**From:** Elliott, Stanice  
**Sent:** Friday, December 23, 2016 11:53 AM  
**To:** 'John Jacquez'  
**Cc:** Rodriguez, Jason T.  
**Subject:** Advanced Auto Parts

Based upon the information provided in your submittal received 12-22-2016, the above referenced plan cannot be approved for CO PERM until the following comments are addressed:

GRADING AND DRAINAGE PLAN

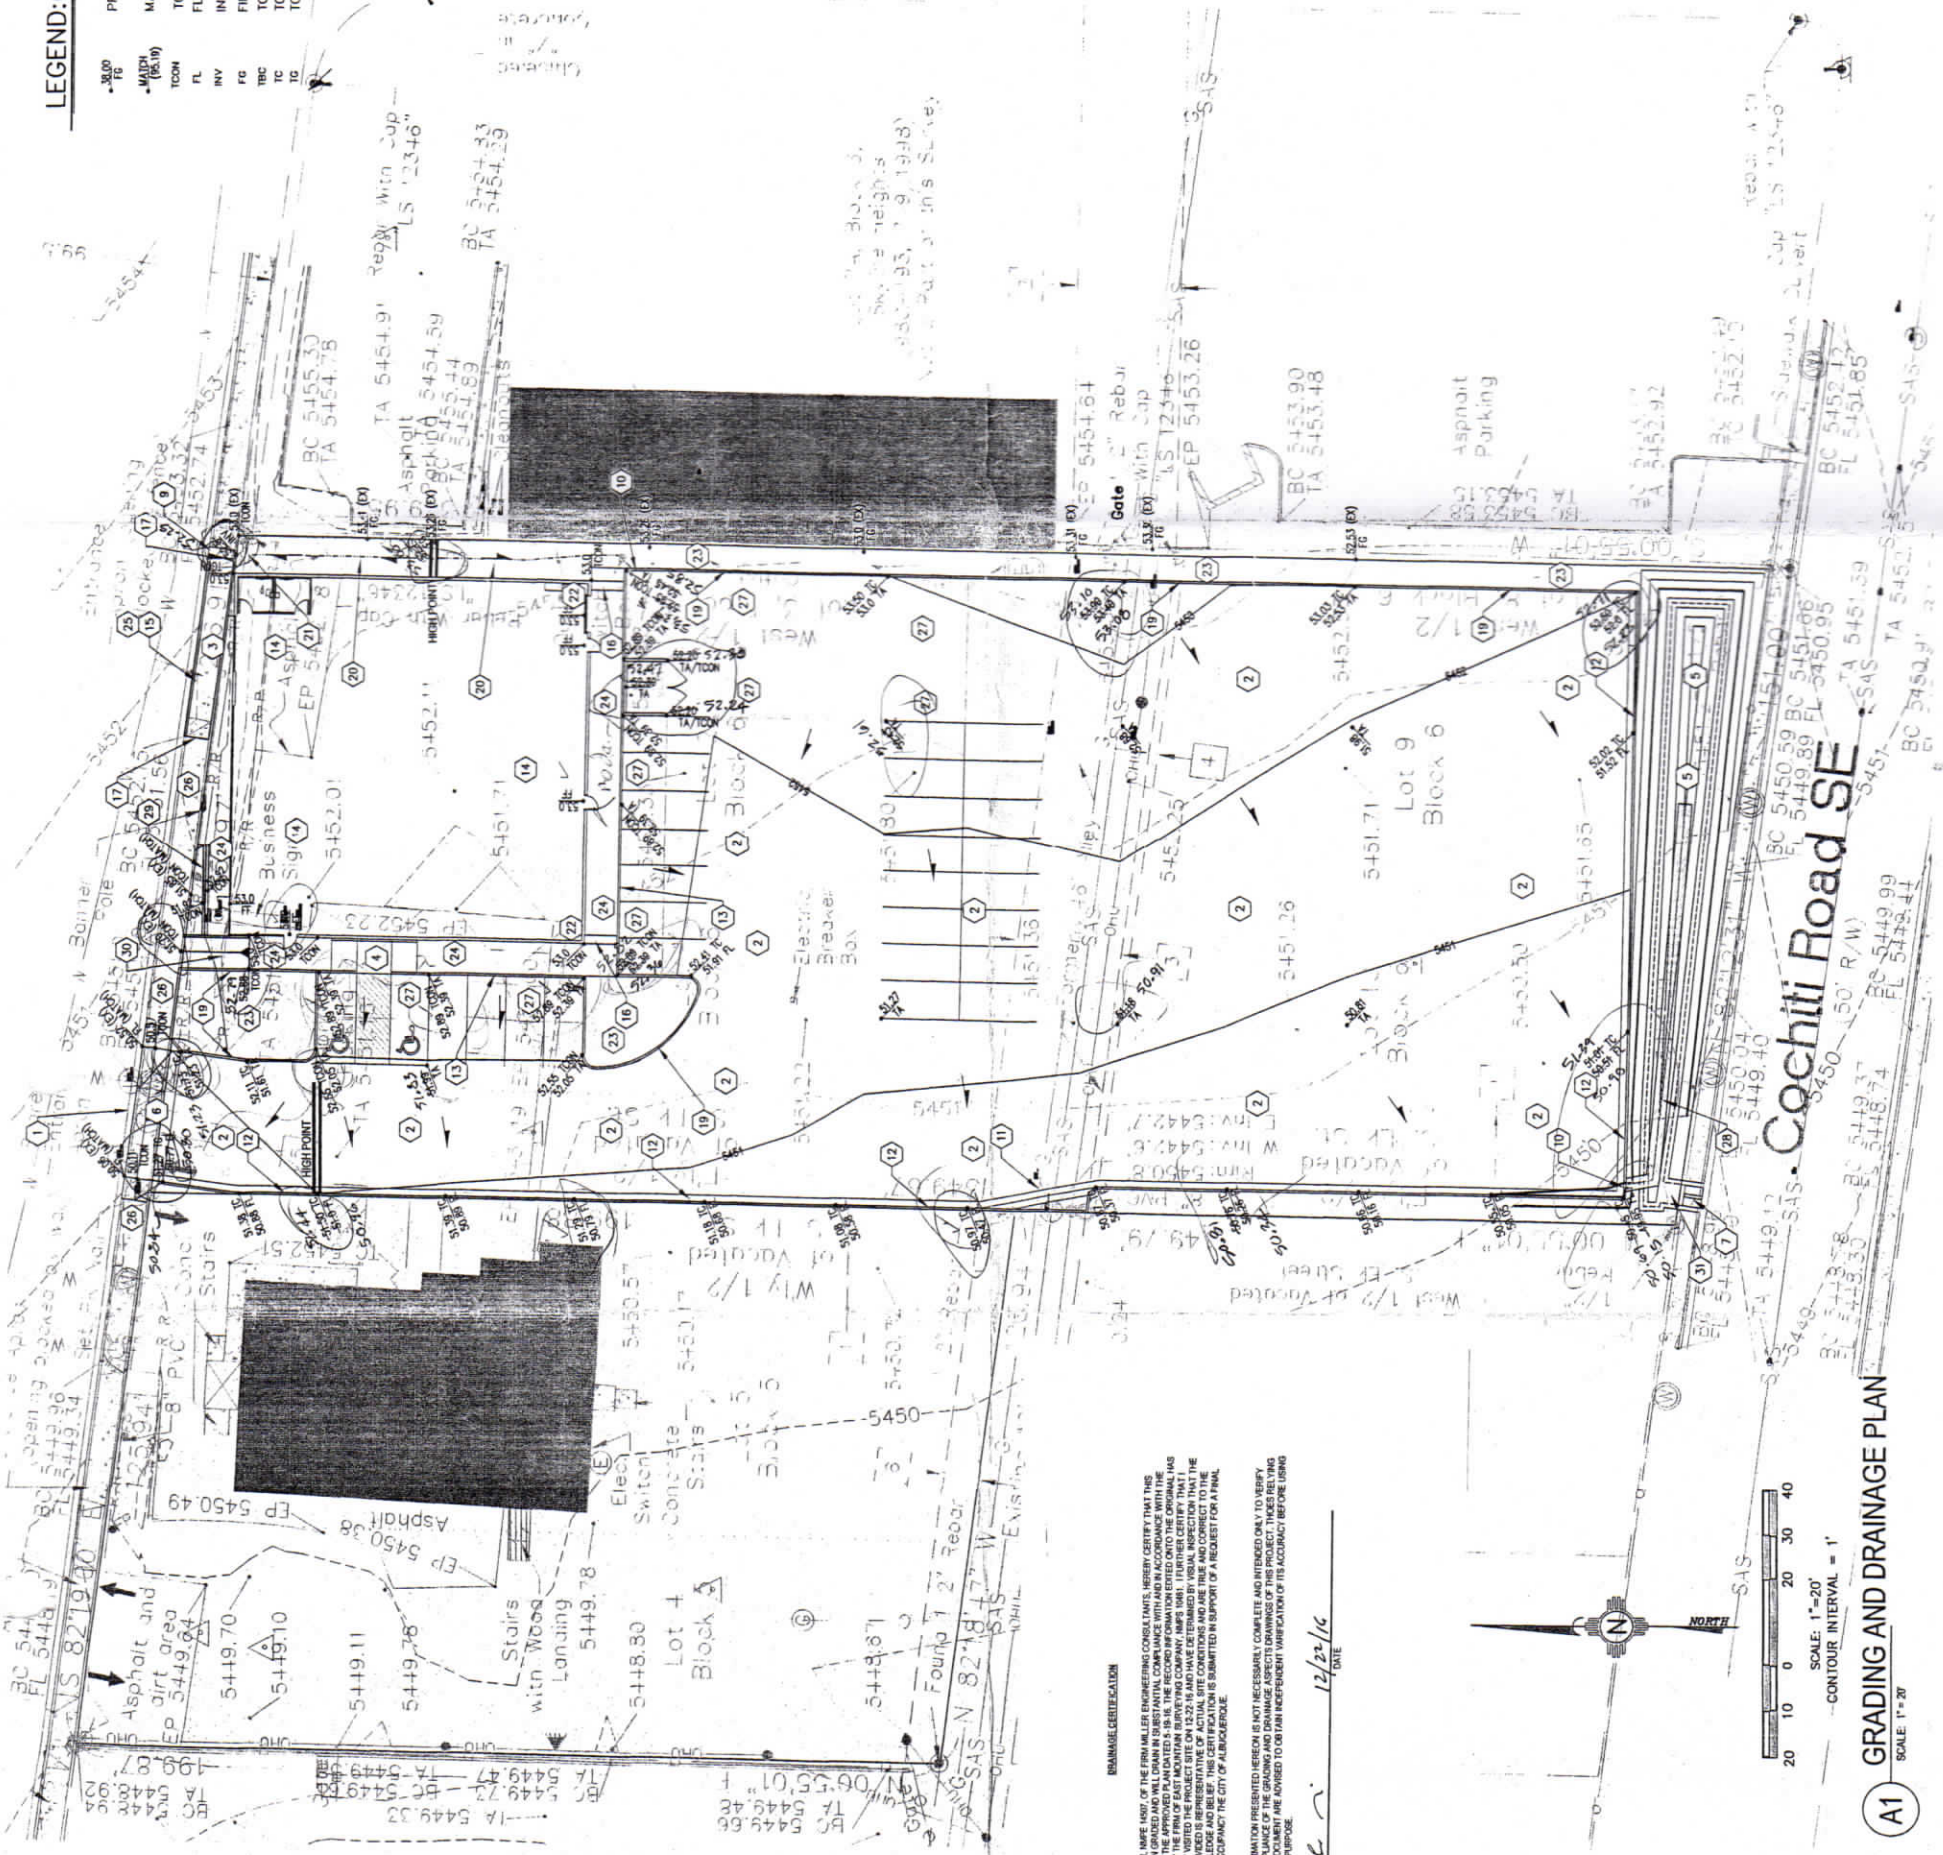
- No site access. Construction fences are completely surrounding site. Unable to do a complete site inspection.
- The sidewalk culverts were under construction
- Line item #31 seems to be incomplete
- Unable to locate note #18 on drawing
